Our Case Number: ABP-318505-23

Re: Proposed construction of a 110kV underground grid connection cable connecting the permitted Carrownagowan windfarm to the existing 110kV substation at Ardnacrusha.
Within the townlands of Caherhurly, Killokennedy, Cloongaheen West, Leitrim, Castlebank, Ballykeelaun, County Clare. (www.carrownagowangridplanning.ie)

19th January 2024

Submission of the Planning Authority regarding application ABP-318505-23 made under Section 182A(1) of the Planning and Development Act, 2000 (as amended)

Trench Sections For Overcrossing Existing Culvert/Service

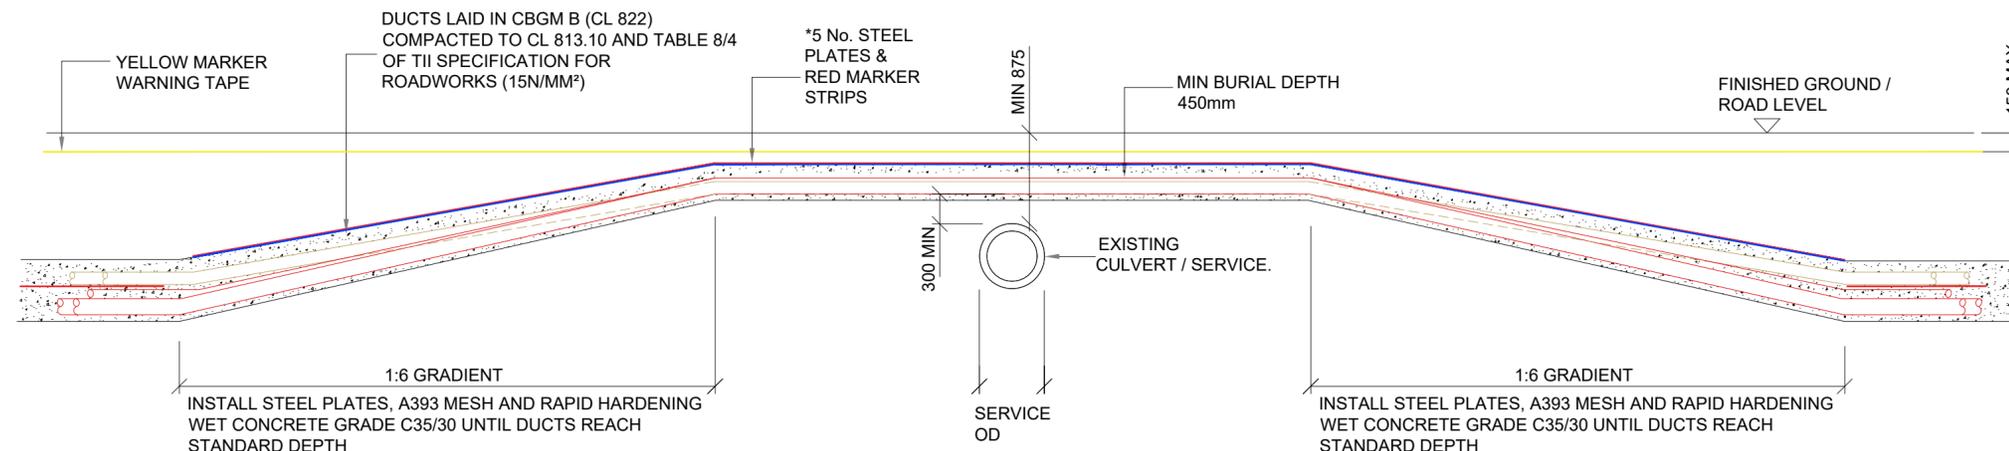
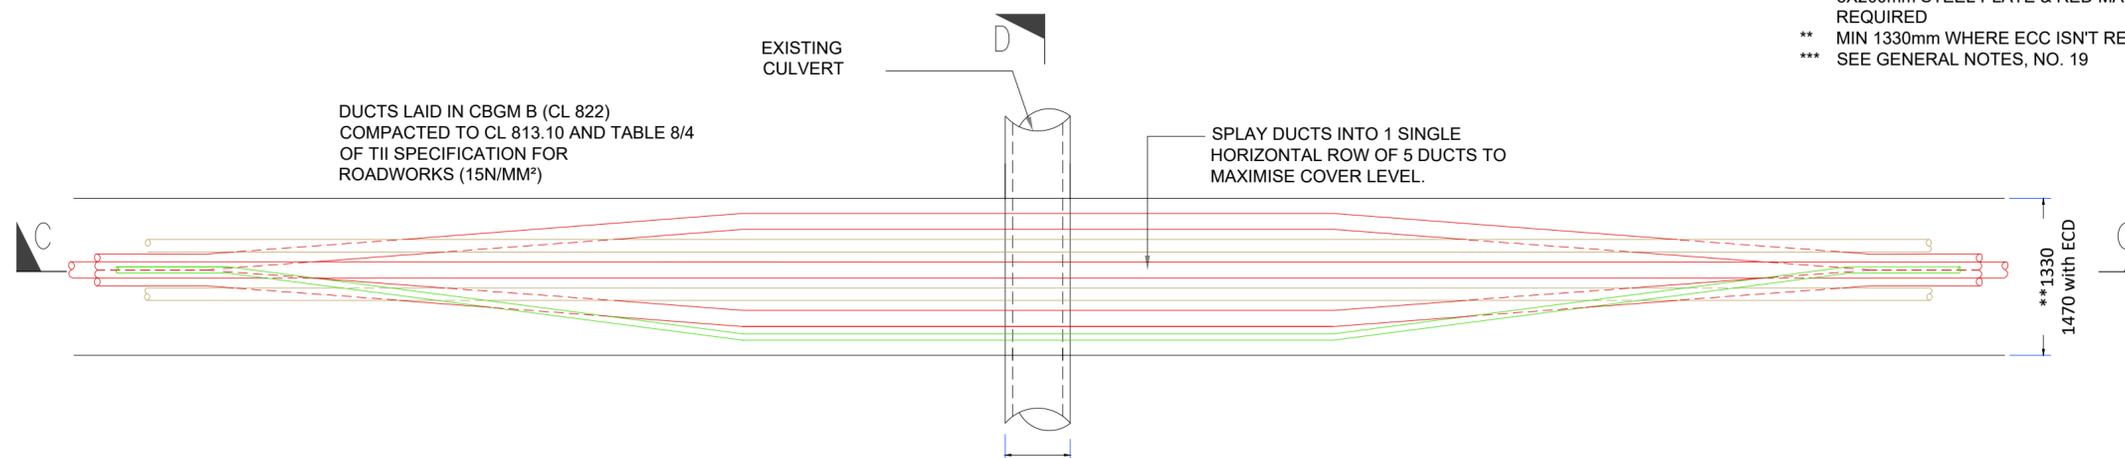
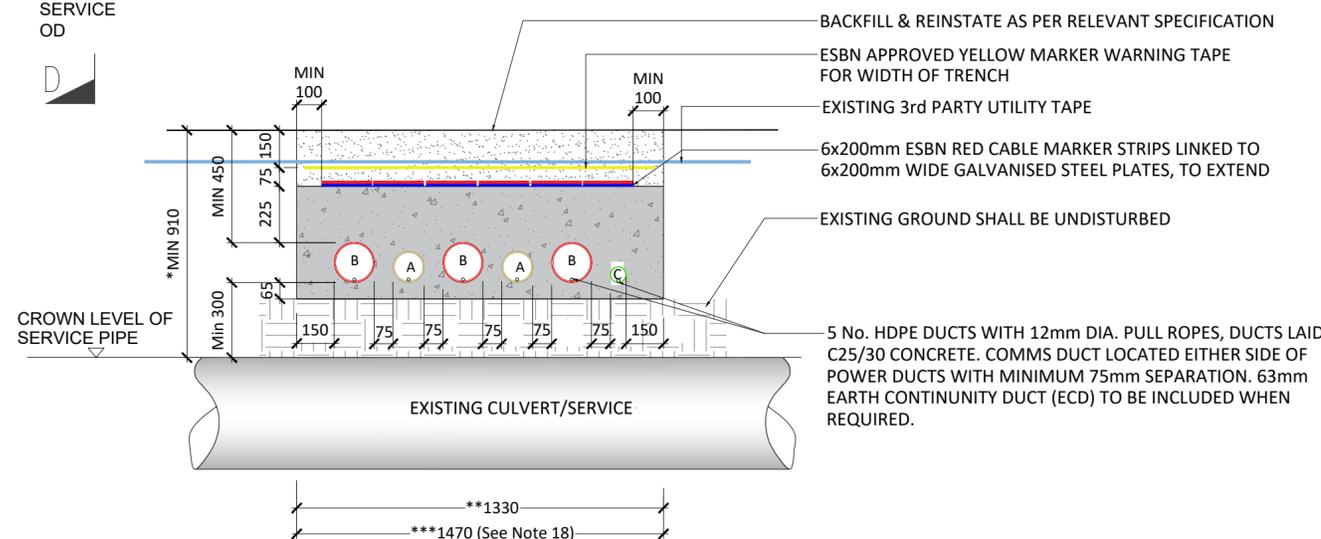
- A pre-condition survey must be carried out on all bridges/culverts and pipelines along the grid route.
- Damage to any structure will require immediate notification to the Scariff or Shannon Offices of Clare County Council. Full replacement of damaged structures and pipelines will be required.
- Post works surveys of each Bridge/Culvert structures will be required.
